Jeanie Bourke - FW: The Inn at Diamond Cove - permit review

From: Barry Yudaken [mailto:yudaken@archetypepa.com]
Sent: Monday, April 15, 2013 12:06 PM
To: David Lloyd; Susan Geffers
Subject: The Inn at Diamond Cove - permit review

CBL: 083E E4600 **Permit ID:** 2013-00436

4/10/2013-JMB/Building:

Project: **THE INN AT DIAMOND COVE, LLC**
 MCKINLEY COURT
 GREAT DIAMOND ISLAND, MAINE

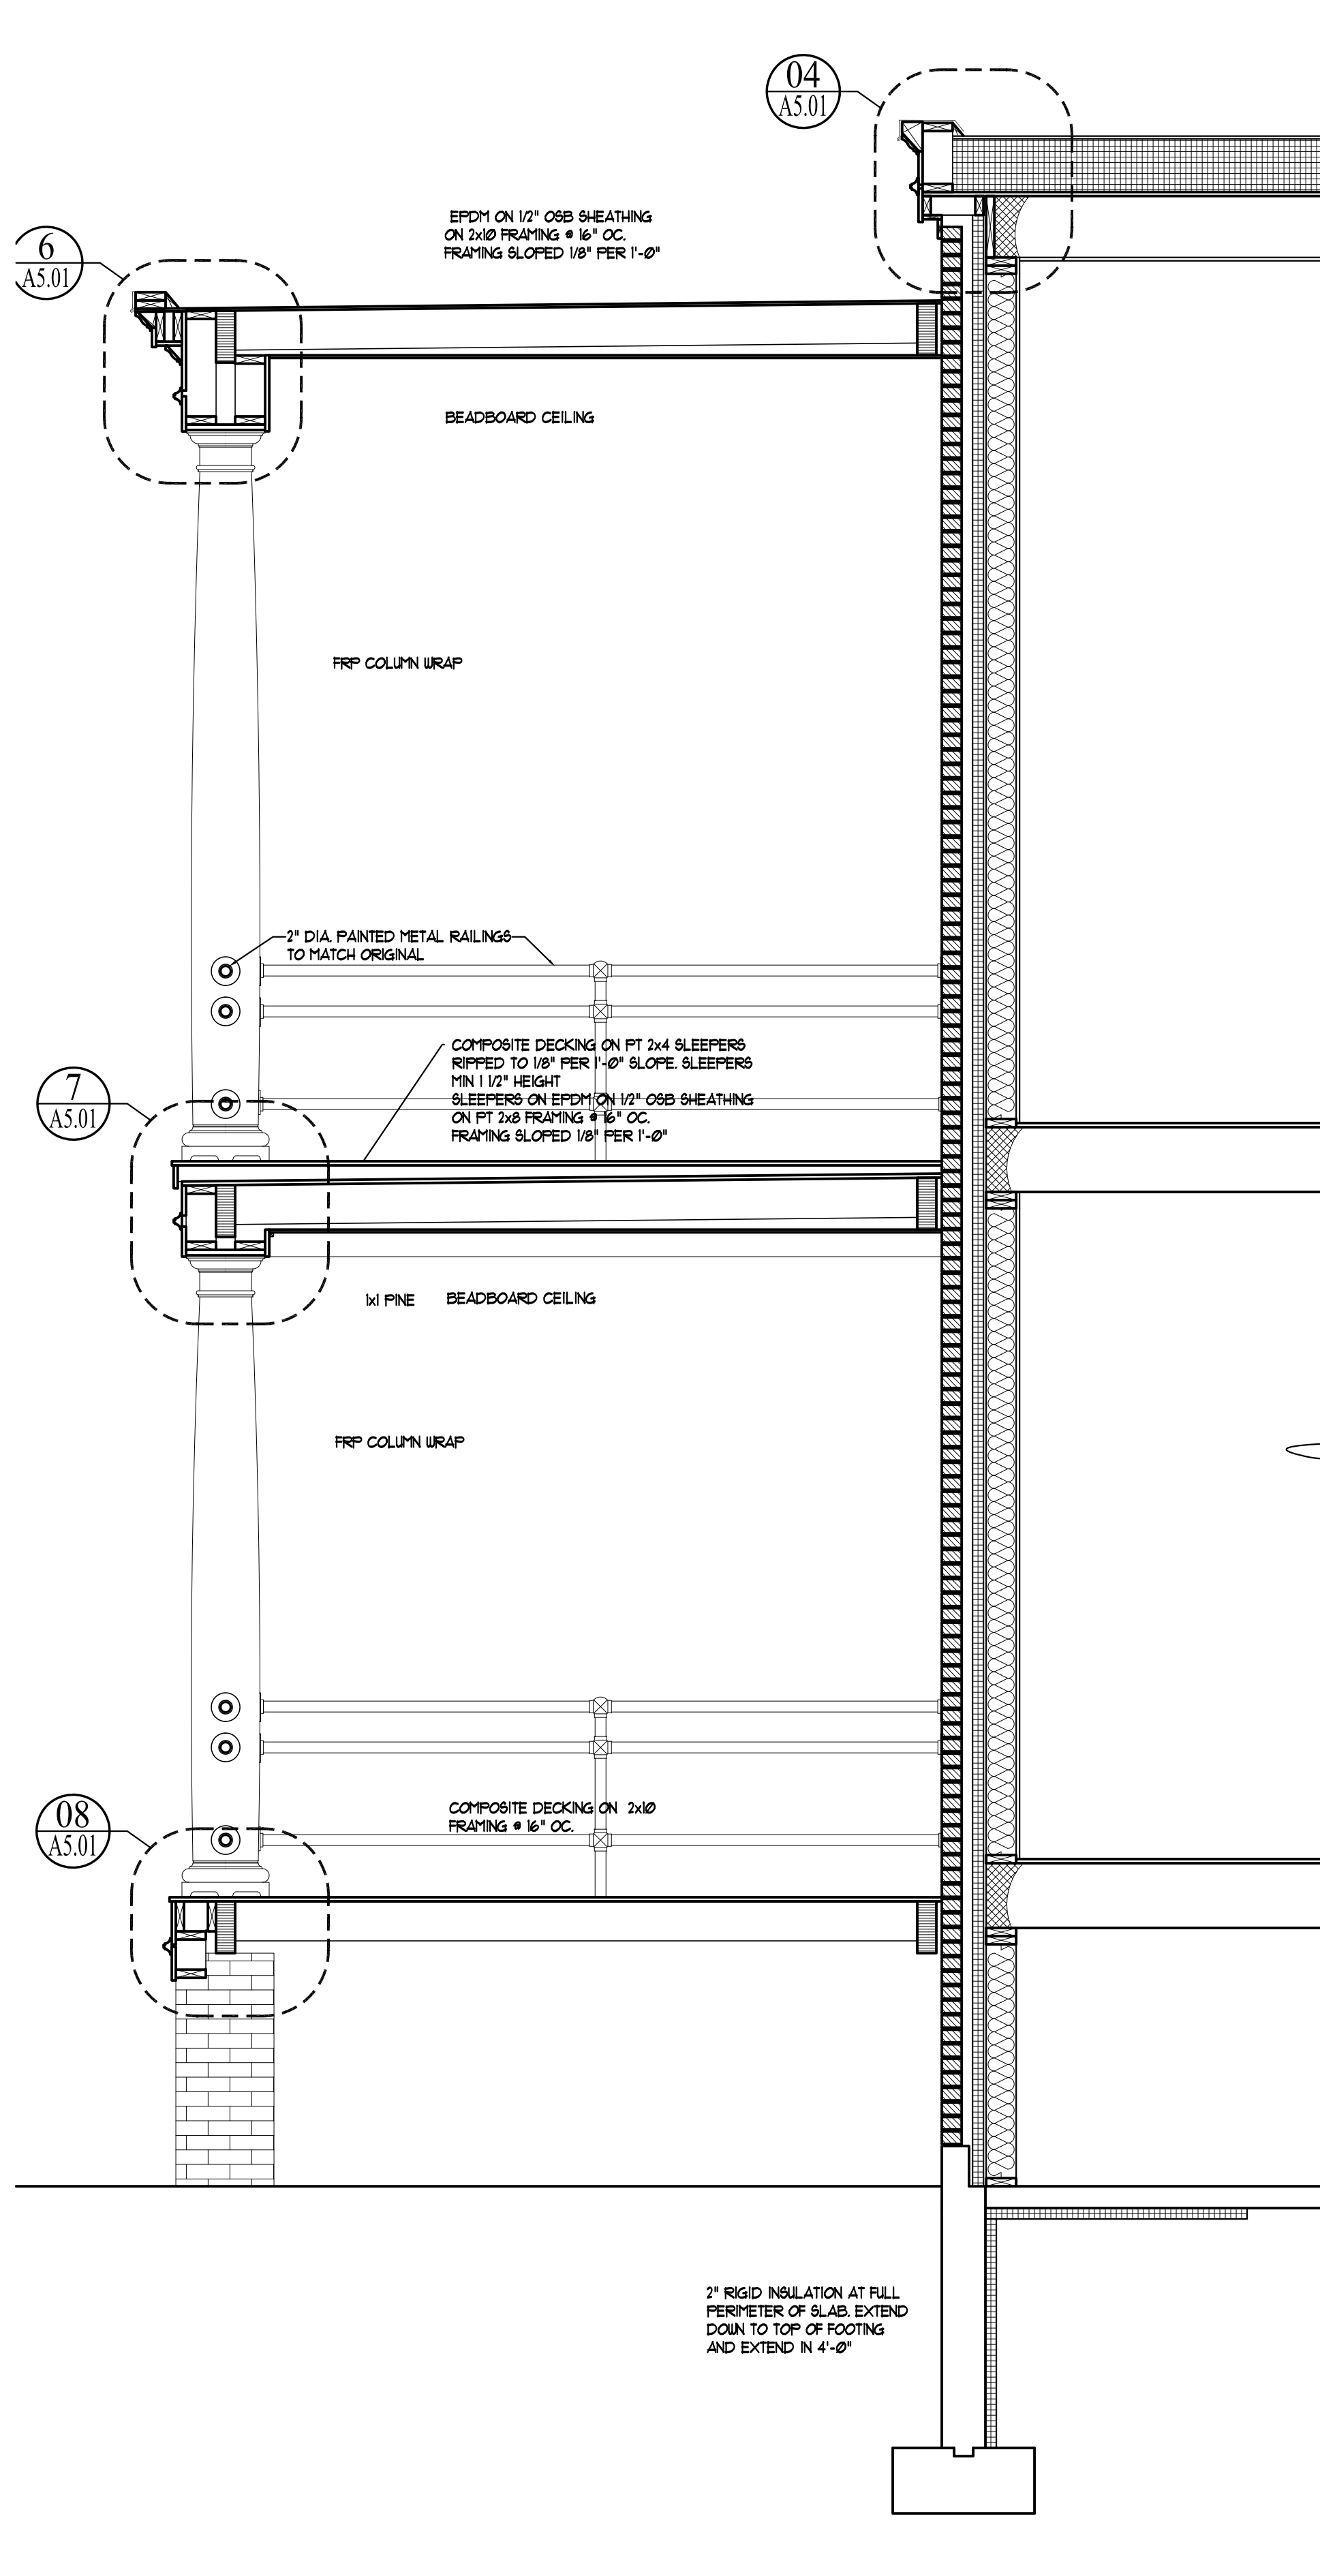
5. Provide tempered window locations per Sec. 2406, **See revised Window Schedule drawing A5.10**
6. Plan A3.10 - wall section - justify the thermal break at the exterior foundation wall from the rigid insulation at grade to the wood framed wall **I don't understand what the problem is with this detail**

A3.11

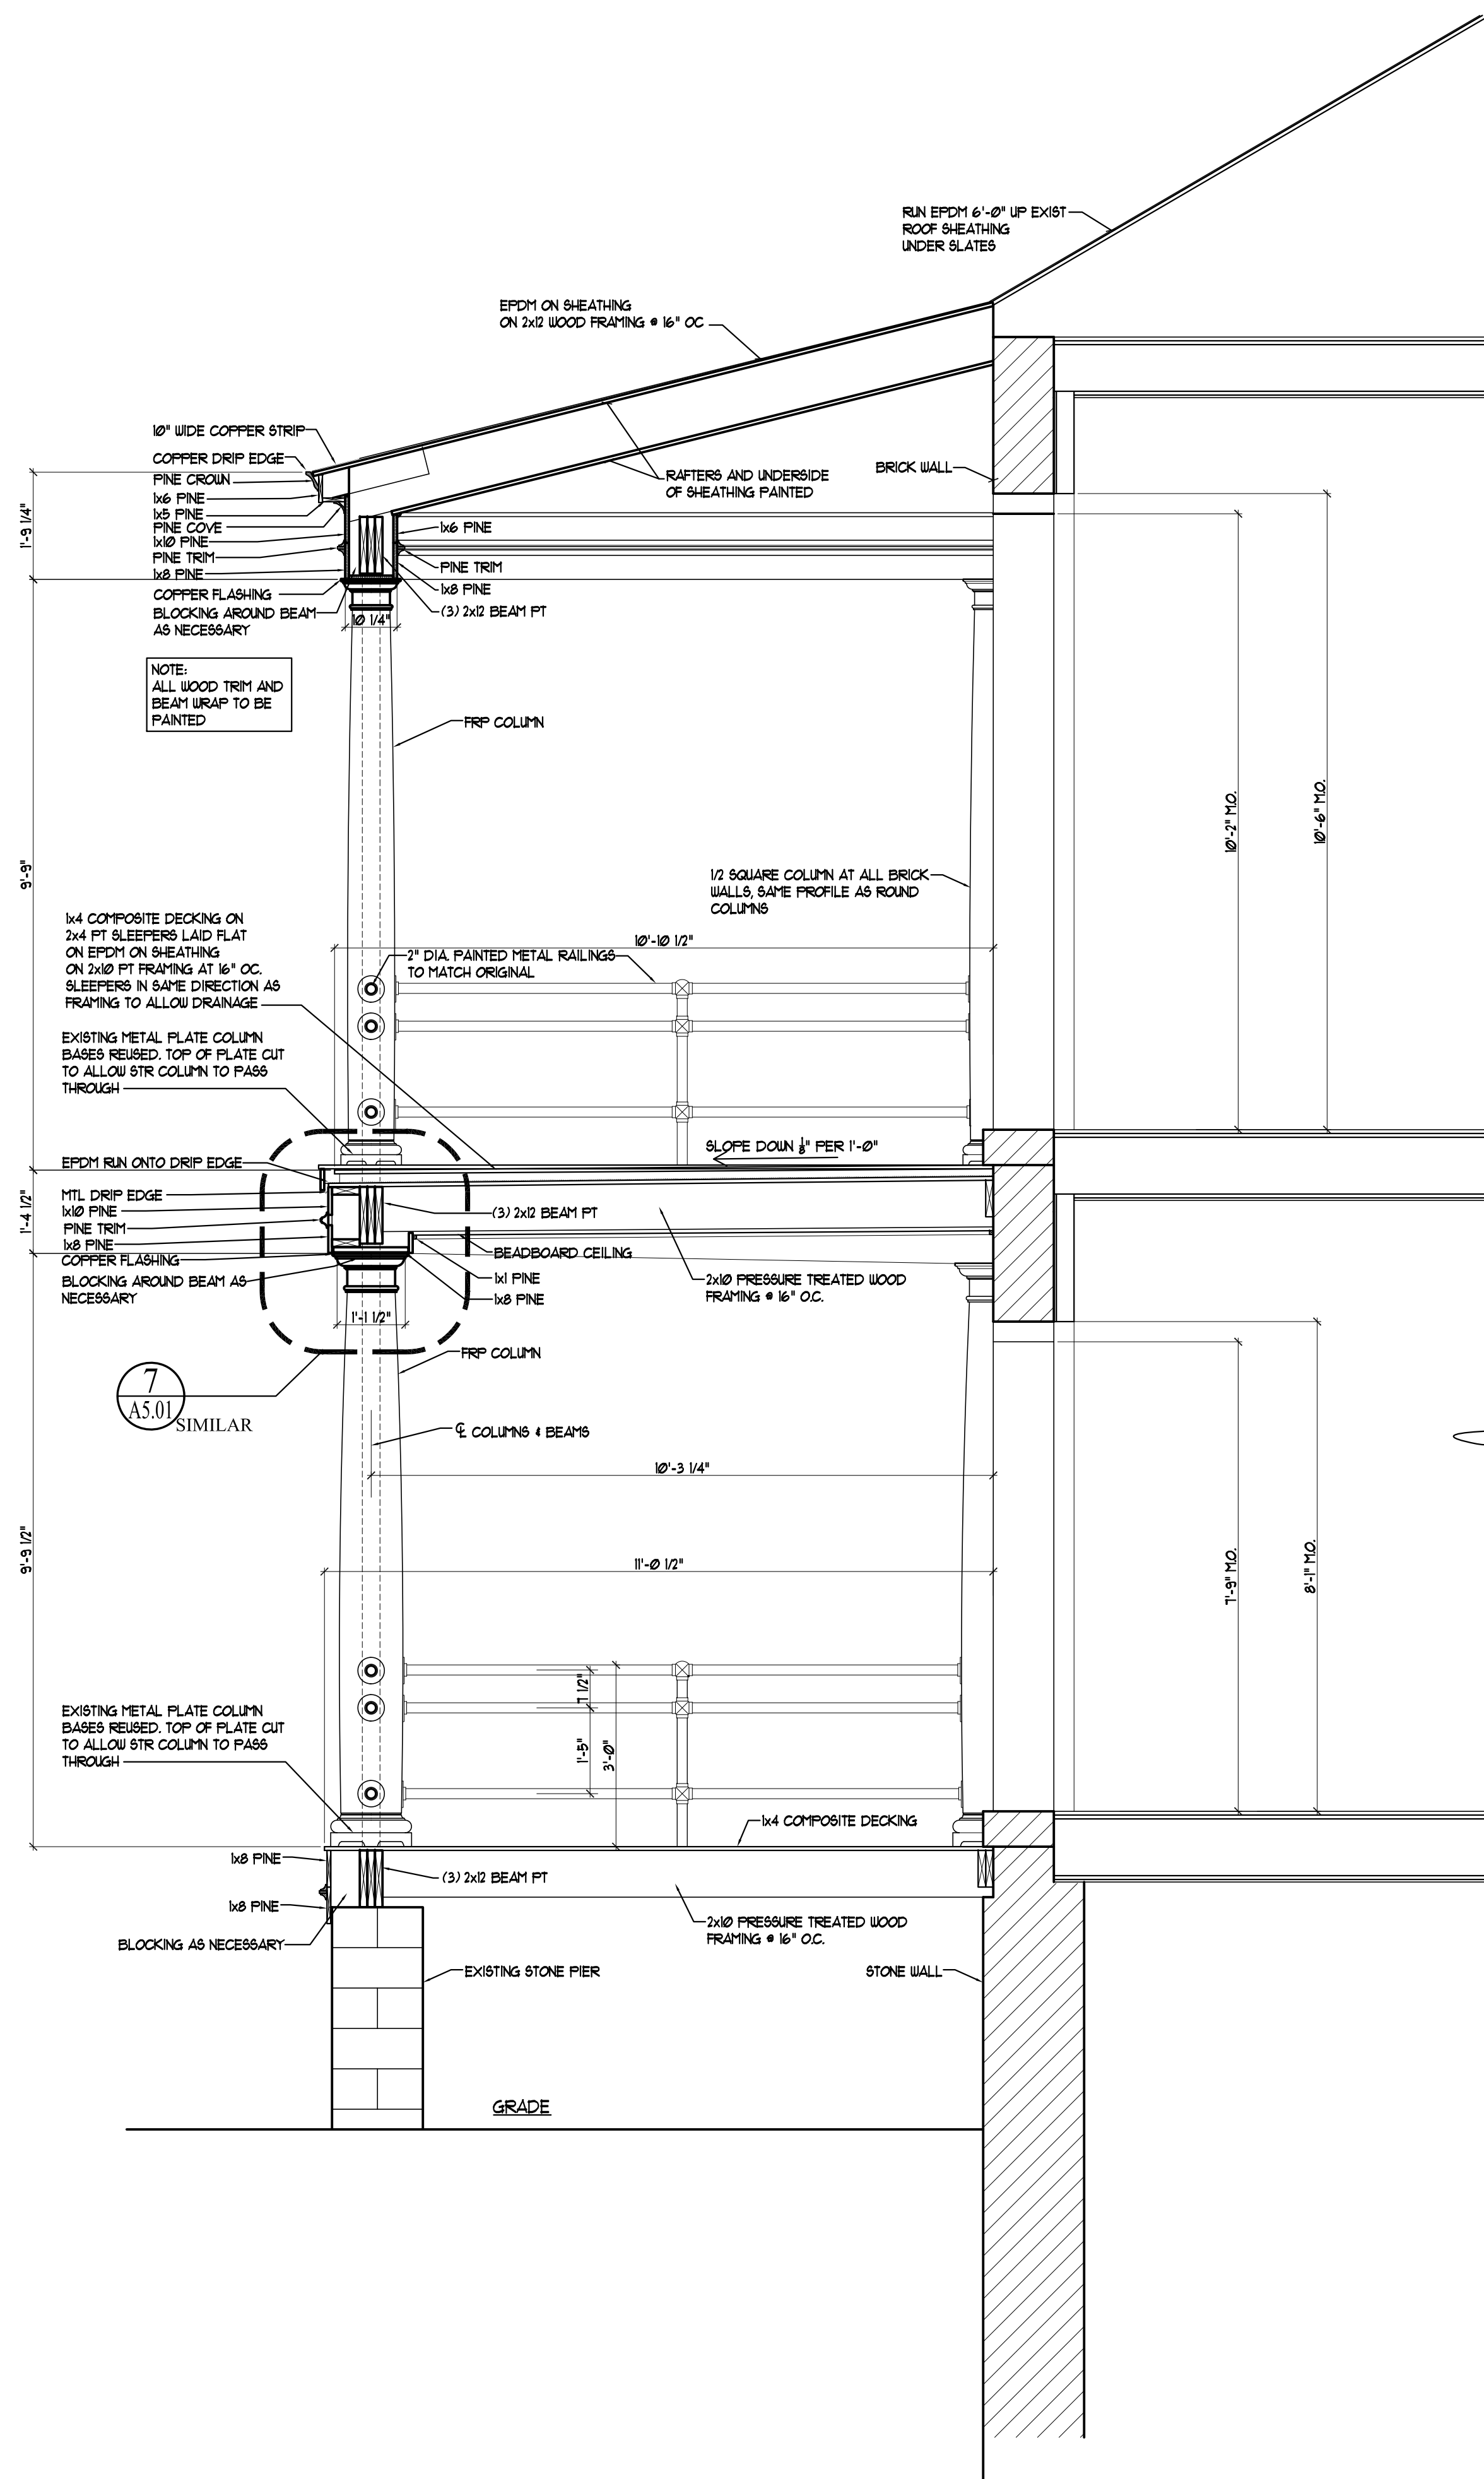
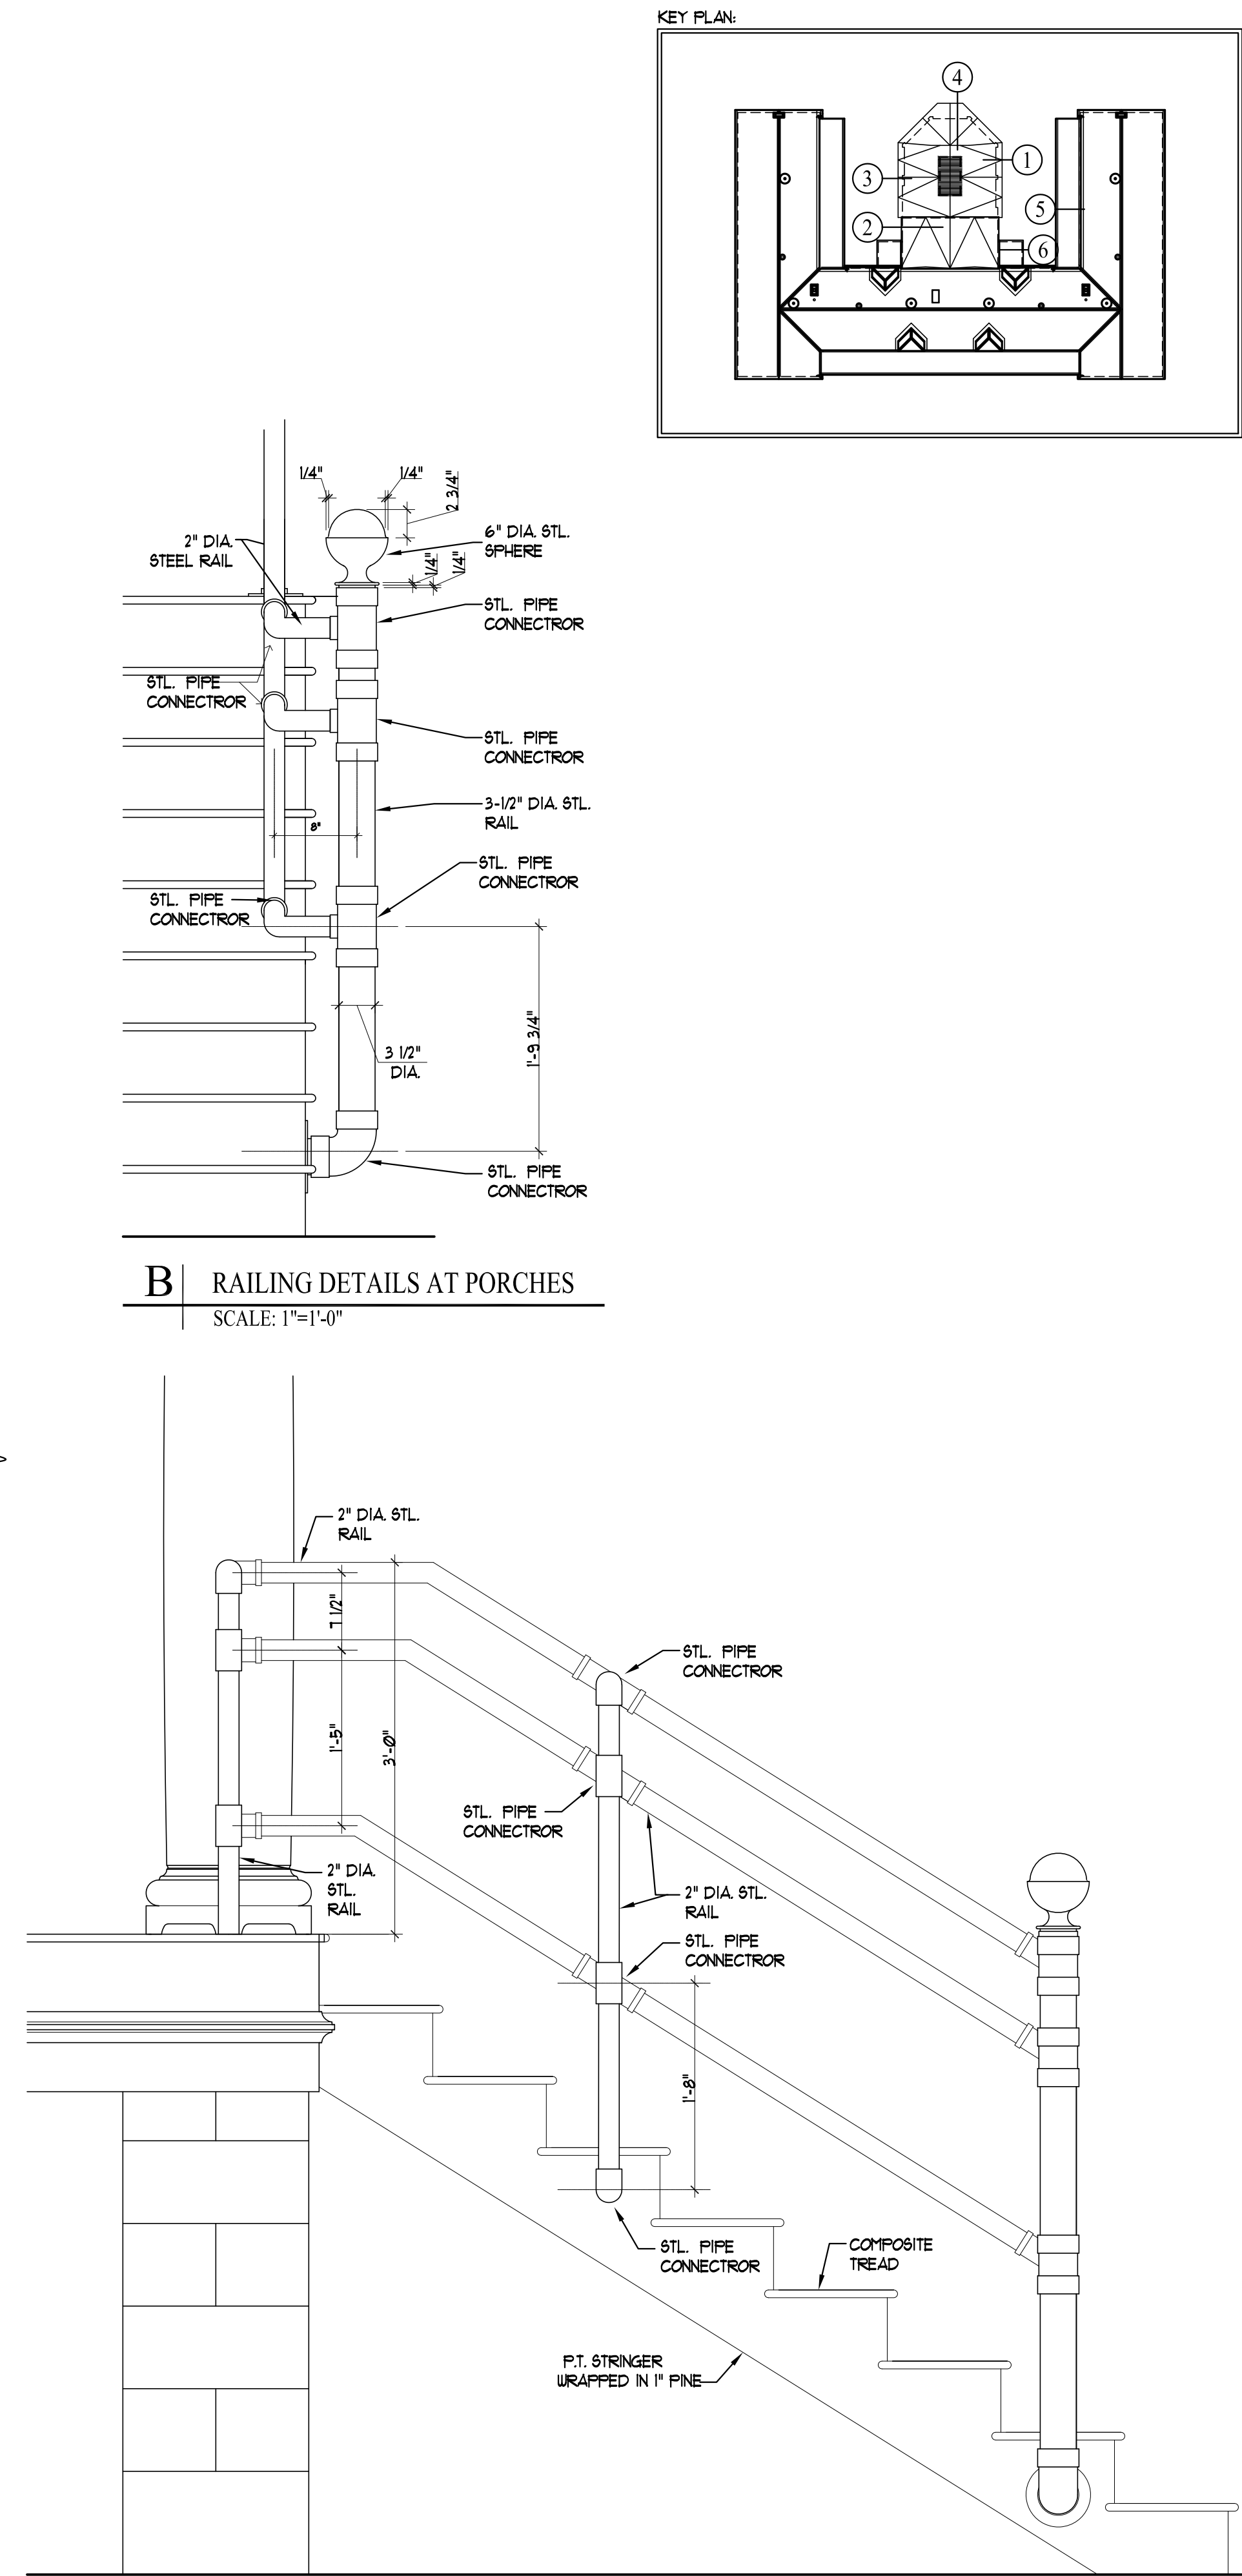
7. Plan A3.11 - Justify exterior pipe rail compliance deviation of code requirements for the opening limitations & height **Section 3409 Historic Buildings . This project is a designated historic landmark being rebuilt under the requirements of the National Park Service. Also all railings approved by Portland HP board we hope to receive**

your blessing that these railings do not constitute a distinct life safety.

14. Provide exterior stair section and dimensional details **see revised stair section drawing A3.11**
15. Are plumbing and mechanical plans completed, at least schematics? **We do not have these at this time.**
